DRB Application No.: 06DRB-00448 (SBP)  
Project Name Rinconada Point, Unit 1  
Agent: Brasher & Lorenz Inc.

DATE: April 10, 2006  
TO: Sheran Matson, DRB Chair  
FROM: Catalina Lehner, Planner *CL*  
RE: Project #1004672, PNM Unser Substation

DESCRIPTION OF REQUEST: SITE DEVELOPMENT PLAN FOR BUILDING PERMIT FOR ELECTRIC SUBSTATION

SOUTH ELEVATION

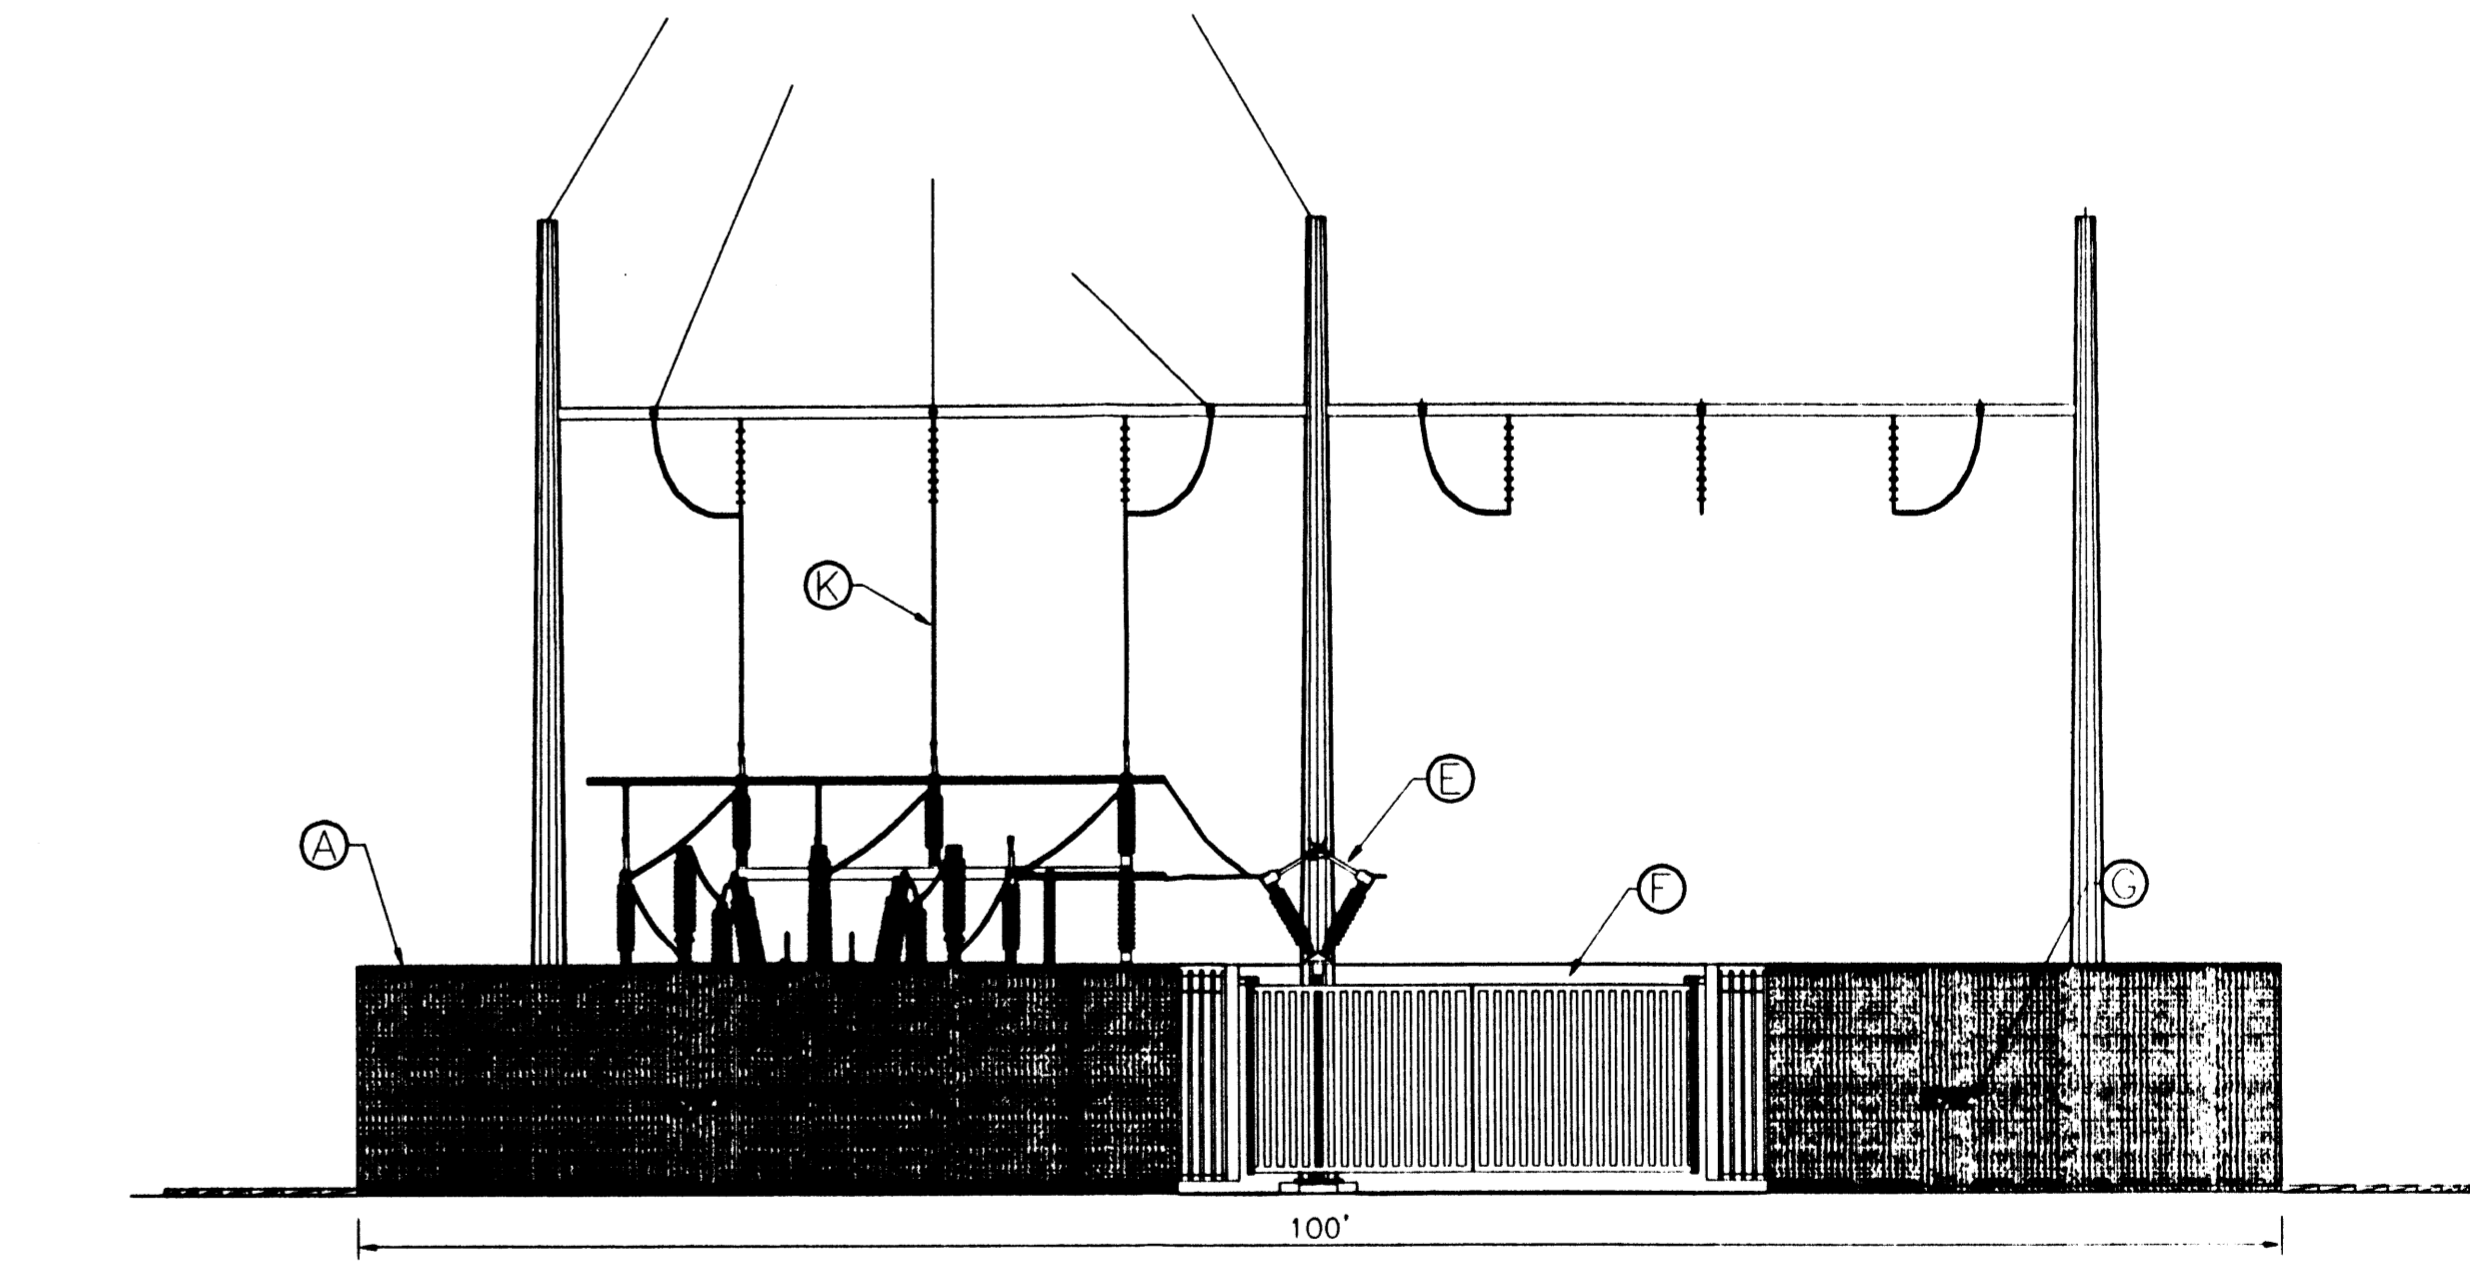
Condition #3 is intended to address Zoning Code §14-16-3-19, Section B (2)(a)-Wall Layout. Staff had recommended incorporation of a design feature. The applicant has added inlaid, smooth-face CMU columns on all wall façades, after 34 foot intervals. Development Review Staff finds this acceptable.
